**KIRKLEES METROPOLITAN COUNCIL
INVESTMENT & REGENERATION SERVICE**

**DELEGATED DECISION TO DETERMINE APPLICATIONS FOR
CONSENT, AGREEMENT OR APPROVAL REQUIRED BY CONDITION**

Reference No:	2025/44/91268/W
Site Address:	Land at, Penistone Road, Fenay Bridge, Huddersfield, HD8 0AW
Description:	Discharge of details reserved by conditions 17 (Retaining walls adjacent to highways), 25 (Boundary Treatments), 30 (Retaining Wall Materials) on permission 2022/93154 for erection of 68 dwellings with associated access, parking, open space, landscaping and infrastructure works (including installation of surface water attenuation tank)
Recommending Officer:	Katie Chew

Officer Report

DRAWING TITLE:
Timber Clad sheet piling 1.8m Fence

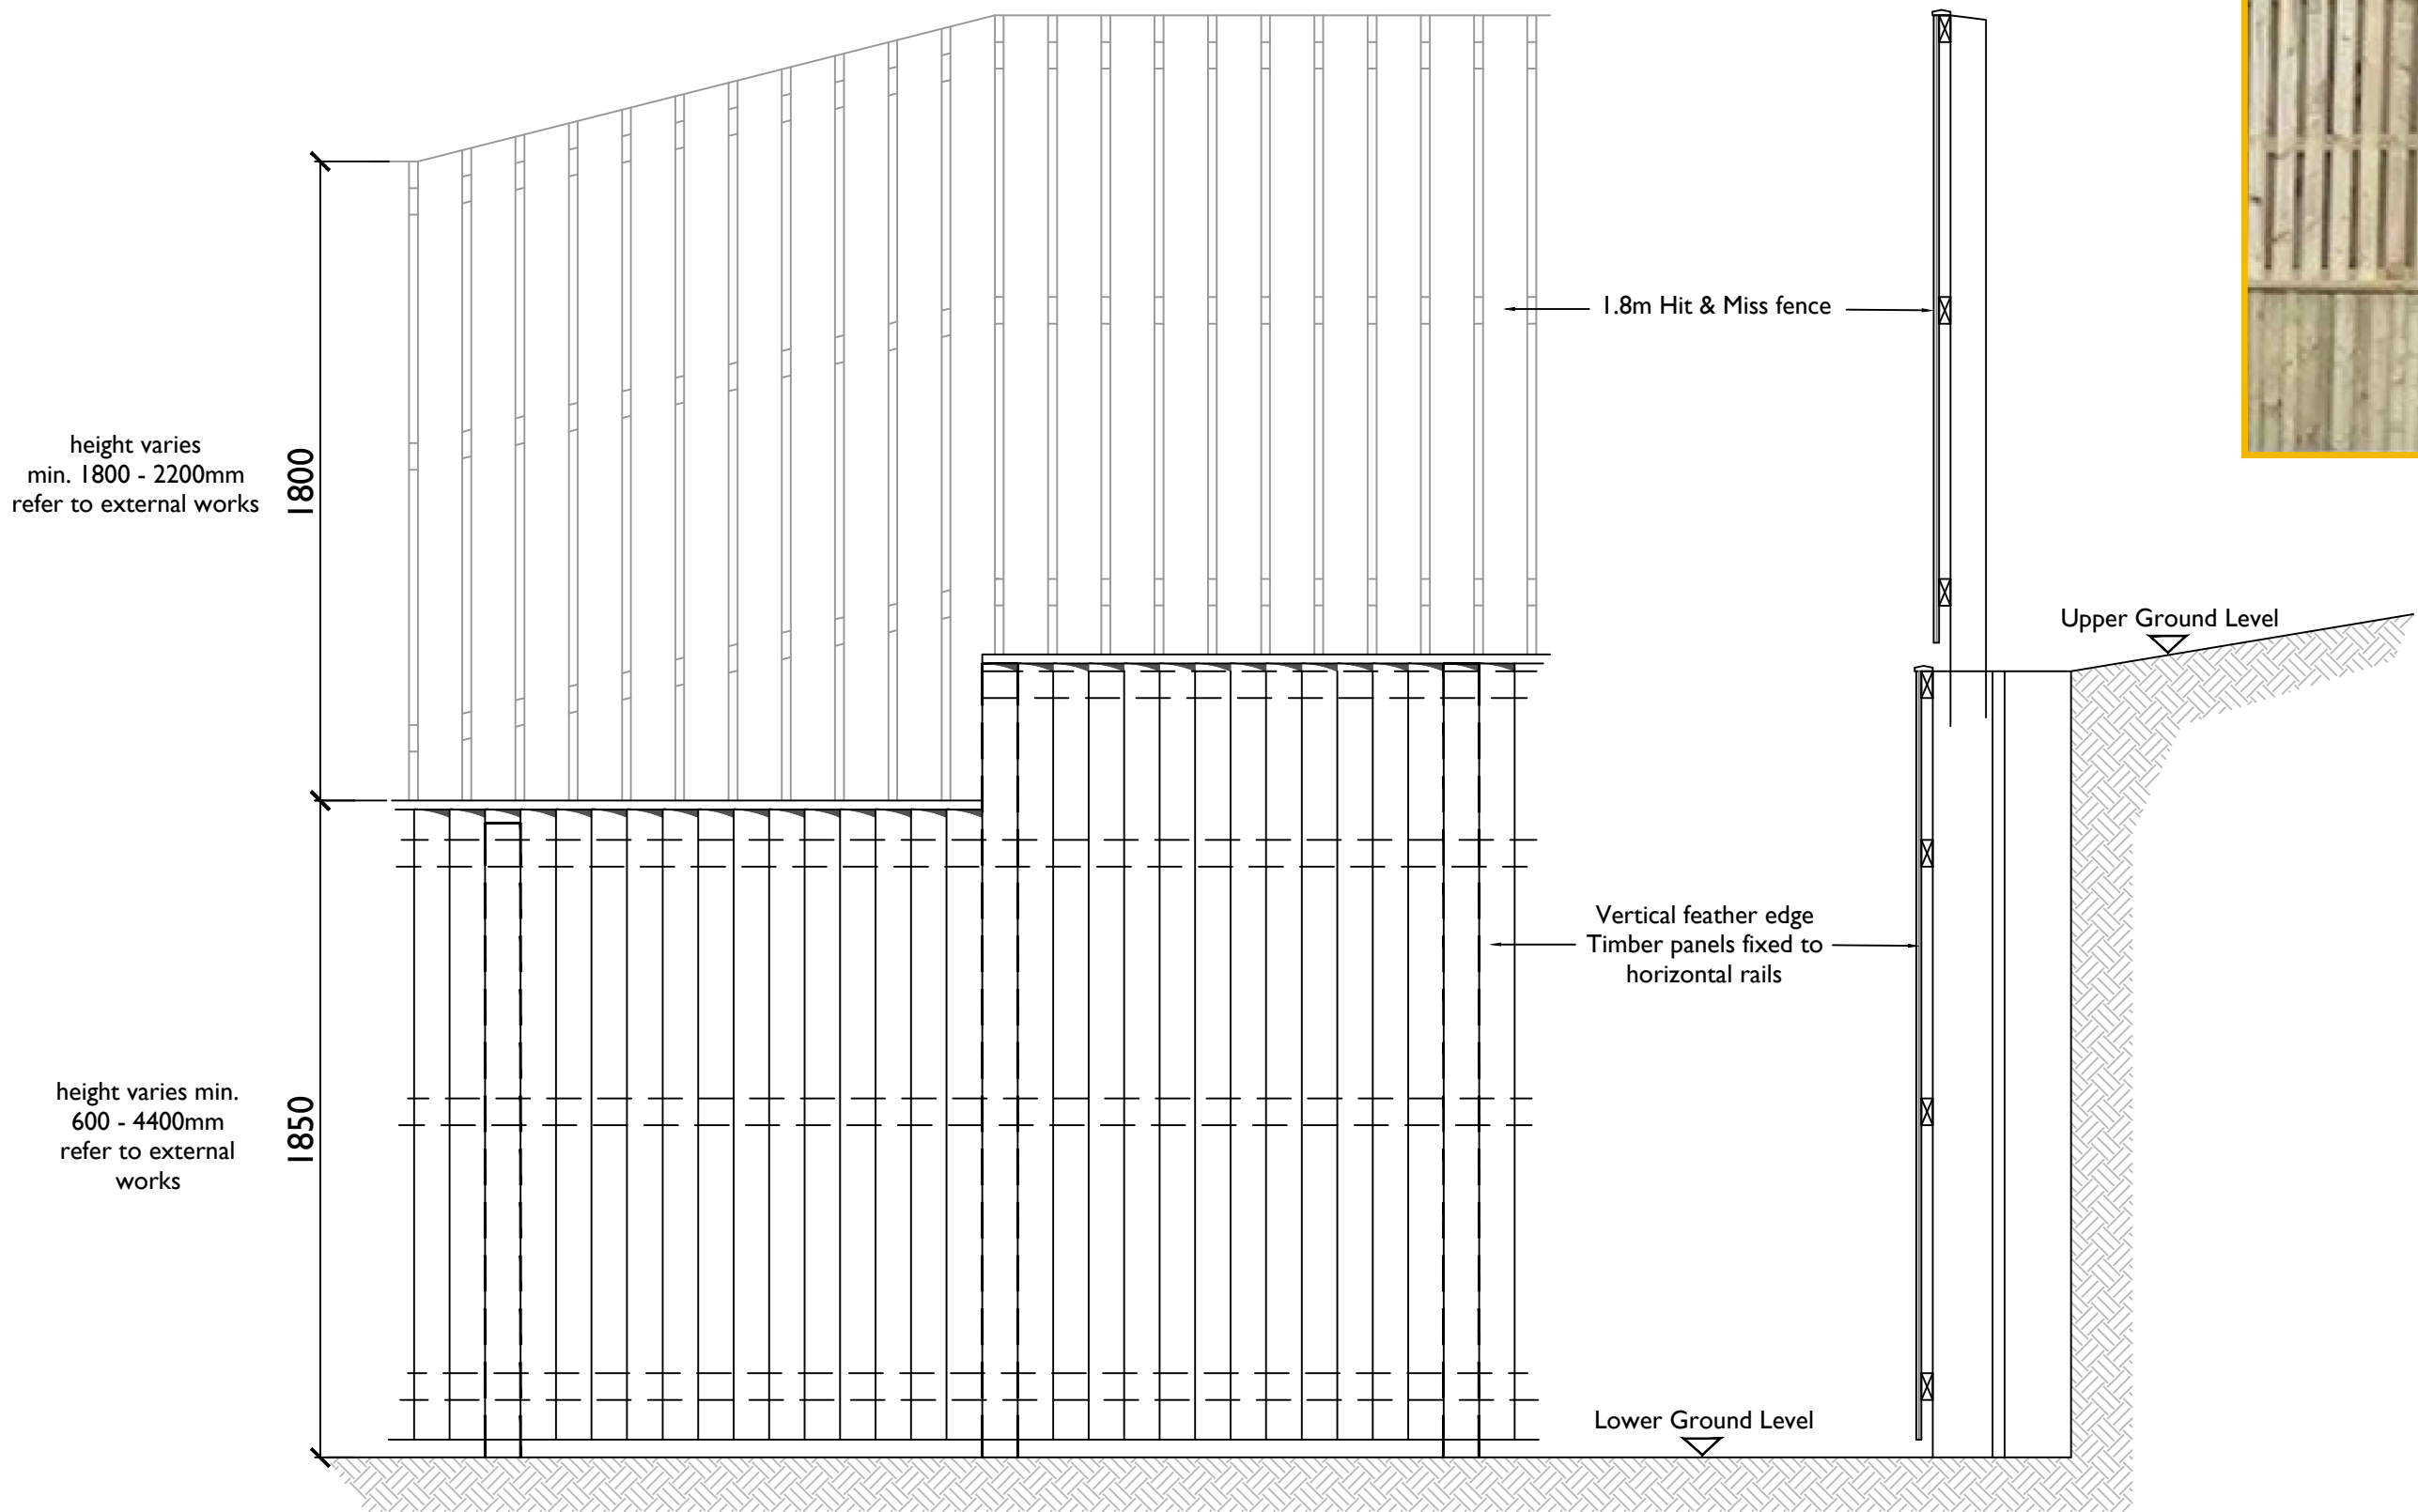
To the rear of plots 5 to 16 Sheet piling and 1800mm timber fence is proposed. The sheet piling is to be clad with Vertical feather edge Timber panels, above these panels is to be a 1.8-2.2m high hit and miss timber fence. Whilst this will in effect result in a the visual appearance of a fence upon a fence, and therefore has the potential to be overly dominant and monotonous, as these boundary treatments are to result in varied fence designs, this will help break up the visual façade of the boundary treatments, and therefore the proposed timber clad sheet piling and fence are considered to be acceptable on this occasion.

DRAWING TITLE:
2m Natural Stone Masonry Wall Detail

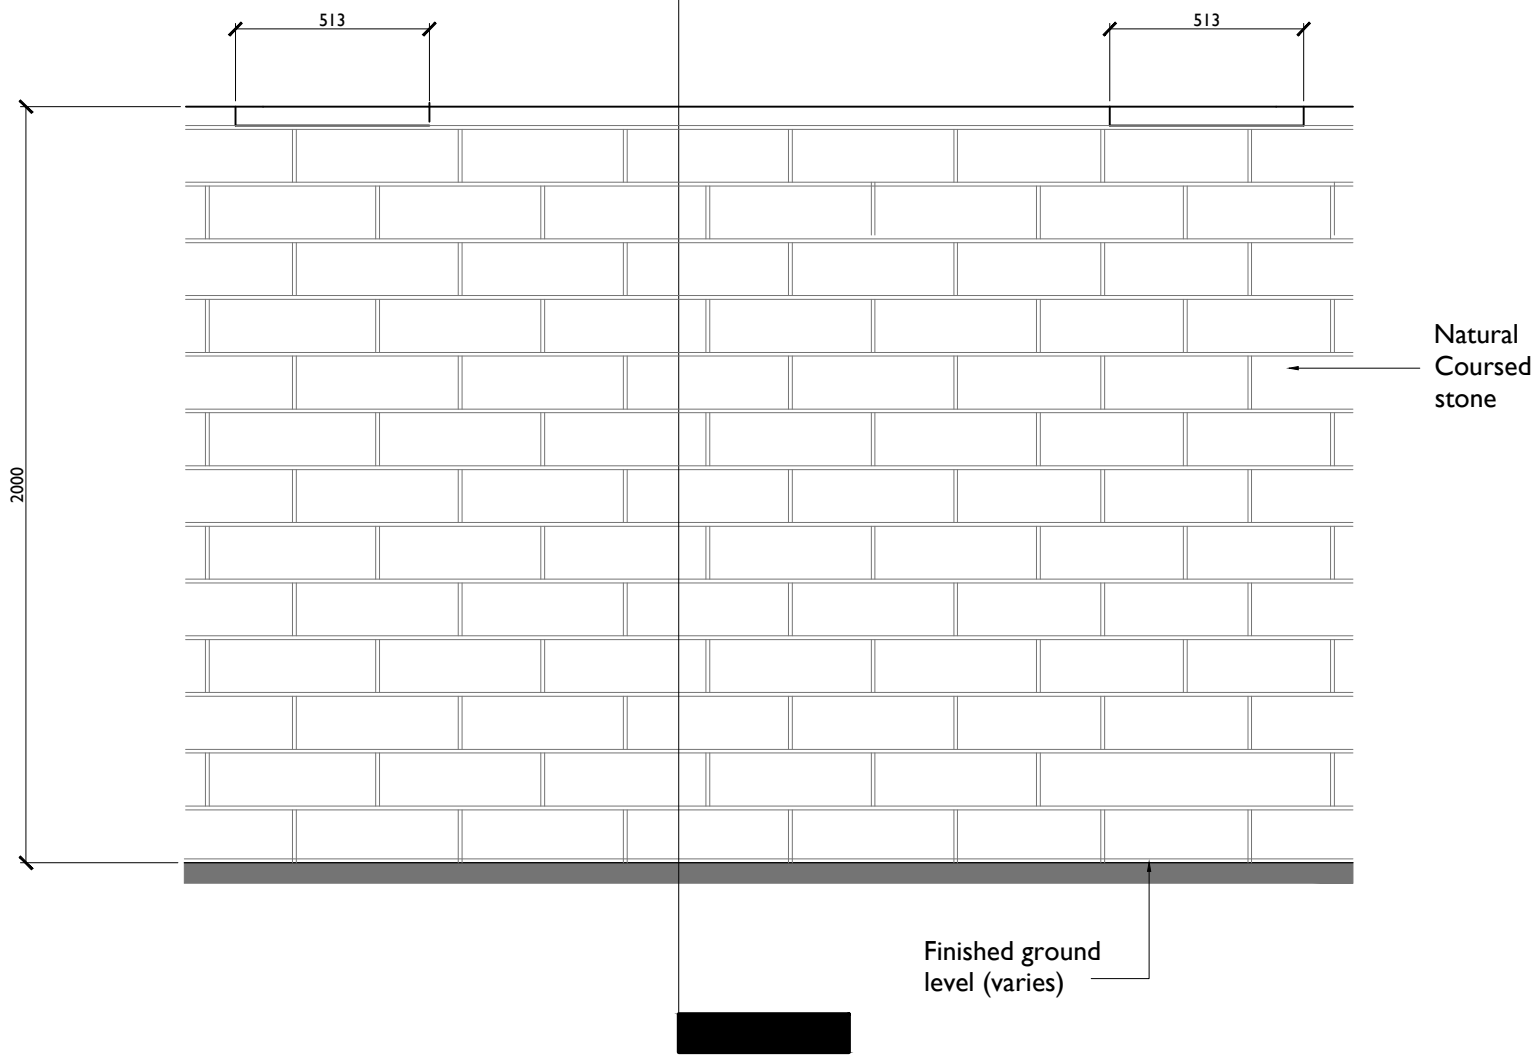
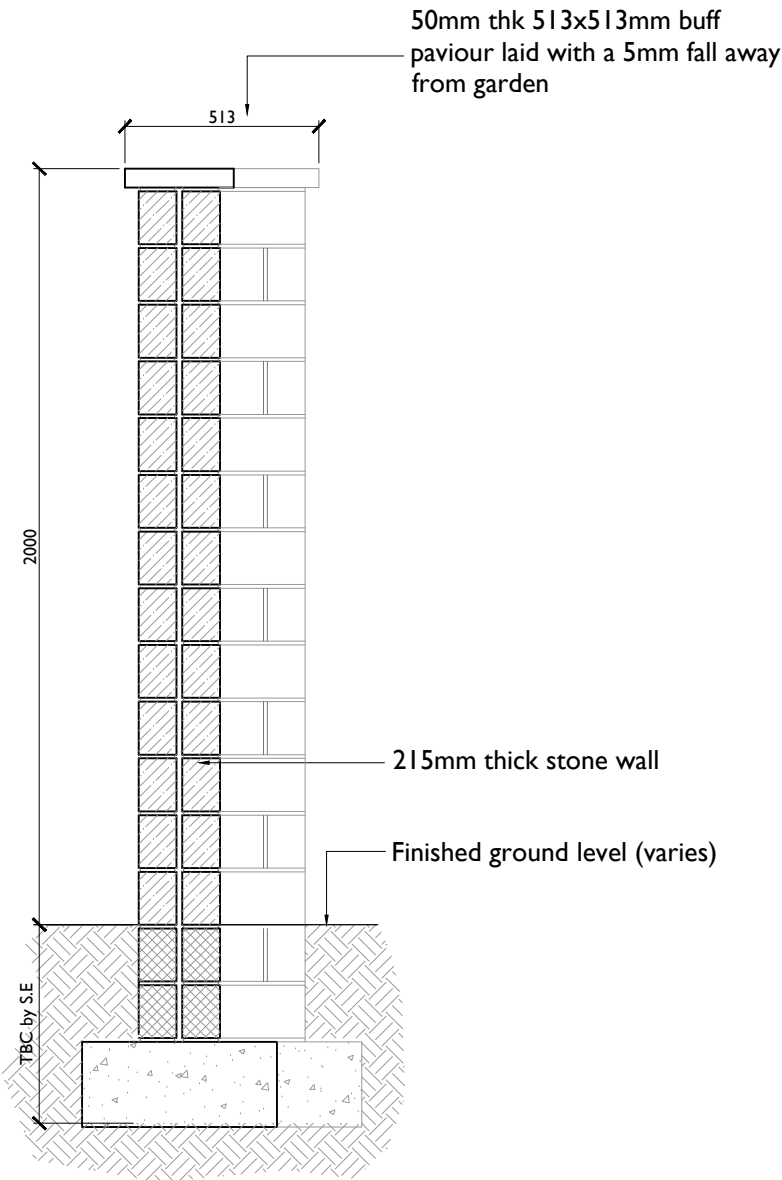
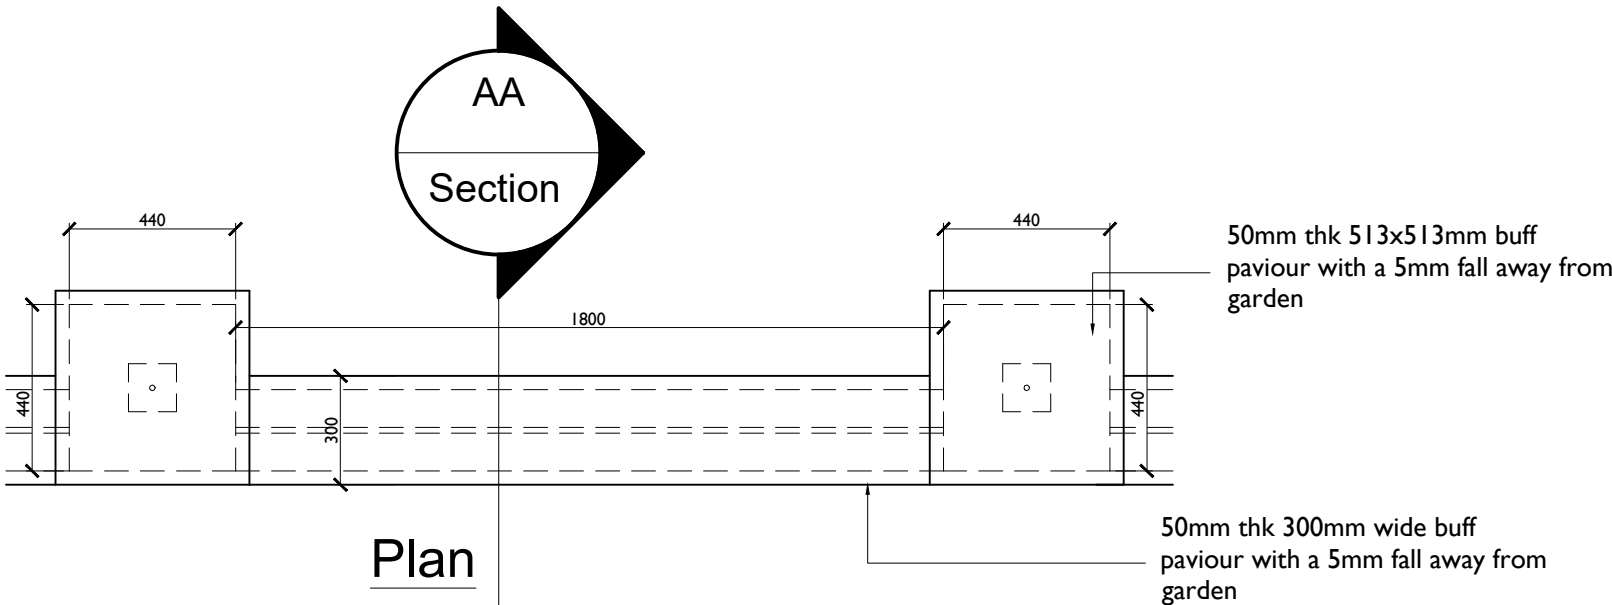
The boundary treatment plan also references a natural stone wall, 2m natural stone wall and natural stone wall with railings, shown within drawings NH/SD/PL/106 & NH/SD/S120/A/02 Rev B. These boundary treatments are to run along the western boundary of the site, adjacent to Penistone Road. The natural stone is to be sourced from AD Calvert's Witton Fell and is to comprise of sandstone 140mm coursed lightly pitched. This is the same as the natural stone secured on plots facing Penistone Road and approved via the discharge of condition application 2024/92428 (condition 28). The quarry is located to the west of Ellingstring and is helpfully identified within the 'Source for Natural Stone for boundary/retaining walls' document, received 08/05/2025. Railings are to comprise of 1.1m high metal railings in a black powder coated finish. Given the above, Officers consider these materials and their locations to be acceptable.
